Rezoning Transportation Analysis
Petition Number: Insert Zoning Petition #2021-226
General Location Identifier: 02902129, 02902130

Date	Description
02-24-22	First Review (PDM)
03-24-22	Second Review (PDM)
04-27-22	Third Review (PDM)

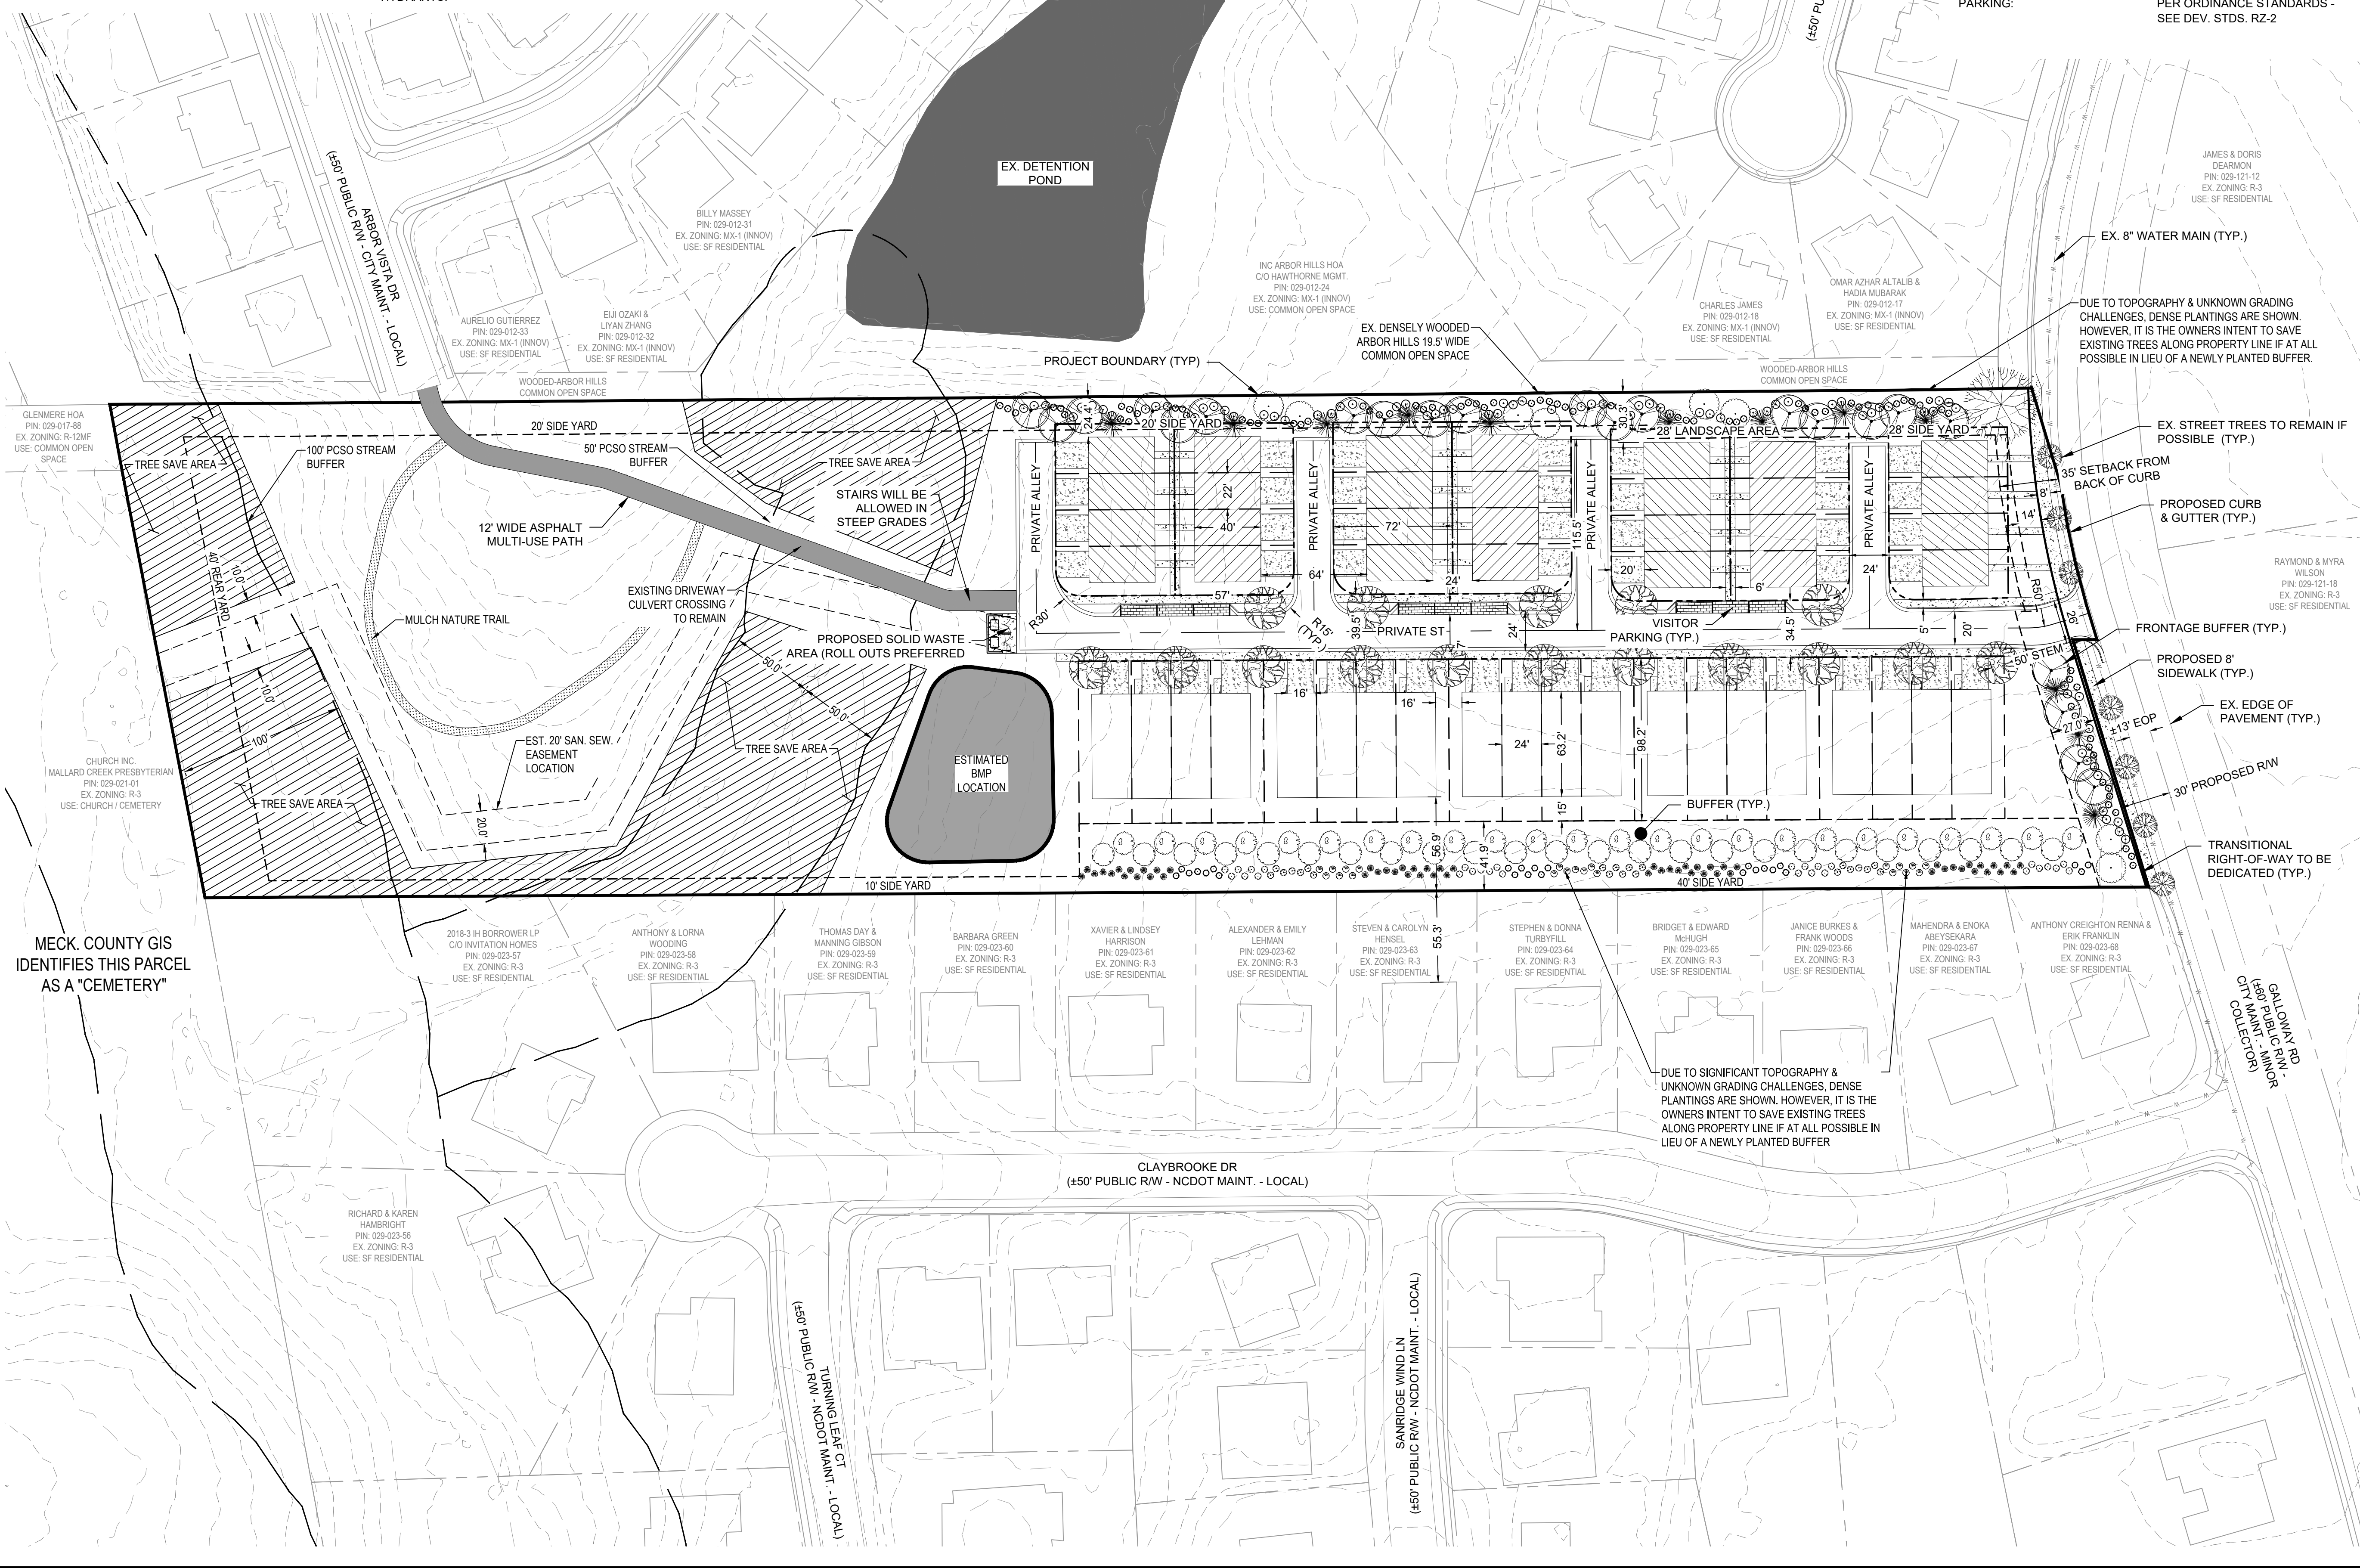
6. ~~Outstanding Comment from 02.24.2022:~~ Revise site plan to provide a minimum 50-foot stem between the proposed right of way and the first residential driveway. Dimension stem length.

7. ~~Outstanding Comment from 02.24.2022:~~ Revise site plan to provide curb ramps for the sidewalk along Galloway Road crossing the proposed private street.

8. Revise site plan to show the entire section of Galloway Road existing curb and gutter along the property frontage. Label and dimension the curb and gutter front the centerline of the road.

10. **New Comment from 04.27.2022:** Revise site plan to remove note regarding stairs allowed for steep grades. The required multi-use path must be accessible, and the request to add stairs between the jogged path was in addition to the required ADA accessible route.
